**Consultation Response from KC,
Trees**

2024/92302 Huddersfield Bus Station, Upperhead Row, Huddersfield, HD1 2JN

Refurbishment comprising (phase 1): facade improvements including Henry Street entrance; replacement shop fronts; alterations to external bus apron; extension and alterations to existing barrier within the bus alighting lane adjacent to Henry Street; (phase 2): new entrance canopy; public realm improvements; cycle hub; facade improvements including replacement shop fronts

Date Responded: 29/08/2024

Title  
**Landscape Proposals - Detailed Planting Plan & Planting Schedule**

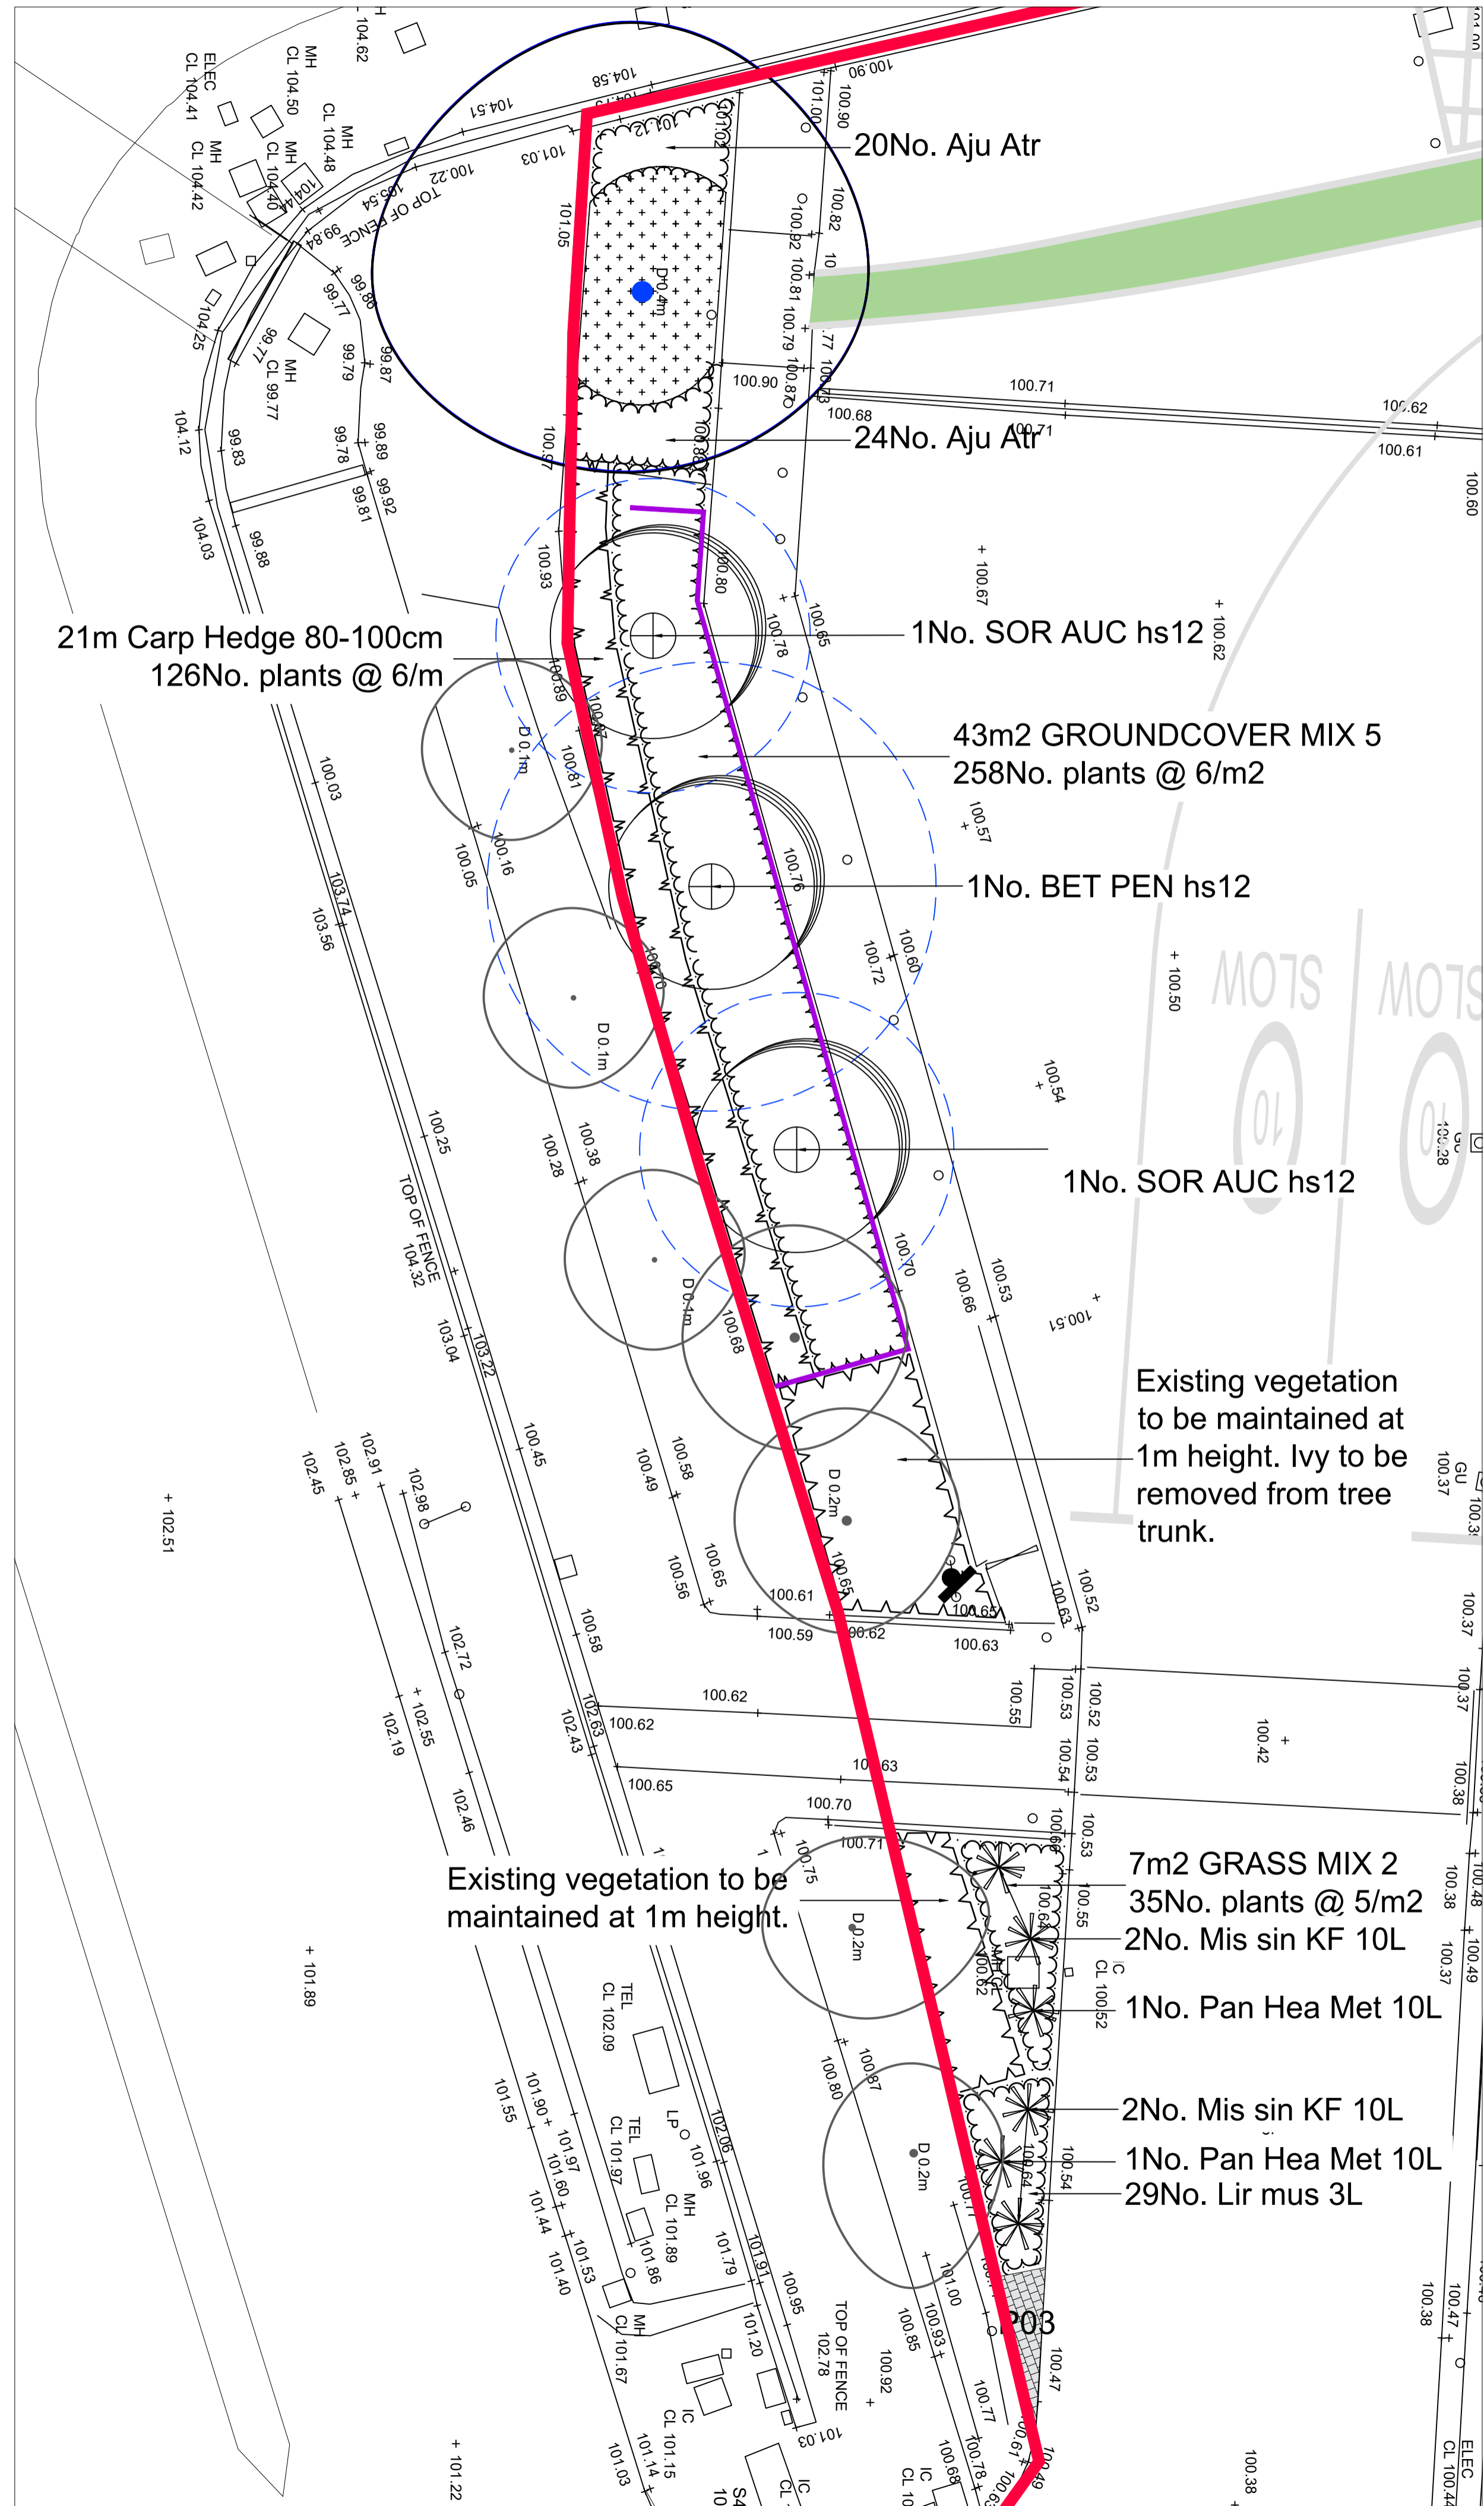
The proposed removal of T11, T12 and T13 will be mitigated with replacement planting somewhere on site however details of the replacement planting is not evident. Providing the replacement planting is like for like in terms of species this shouldn't be a problem as T11, T12 and T13 are all street trees in tree pits.
